6 October 2021

Barnham and Eastergate Parish Council response to planning application AL/113/21

At a meeting of Barnham and Eastergate Parish Council's Planning & Environment Committee held on 21st September 2021 the Committee resolved to submit an objection to Planning application AL/113/21 – and at Bayards, Level Mare Lane, Eastergate:

Figure No. 01 - Bat Activity Survey
Land at Fontwell Avenue, Fontwell, Eastergate, West Sussex

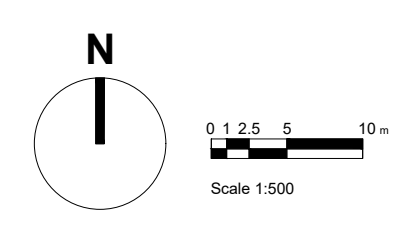
The Bat Report mentions static bat monitor recordings made at the site for 28 nights during 2020. Section 3.1.6 refers the reader to 3 deployment location for these,

which it states are plotted on “Figure 01.” However, the deployment locations of the static bat monitor do not appear on Figure 001. Data was recorded for *Myotis* species of bat during static and transect surveys at the site, which also appears to have been omitted from Figure 001.
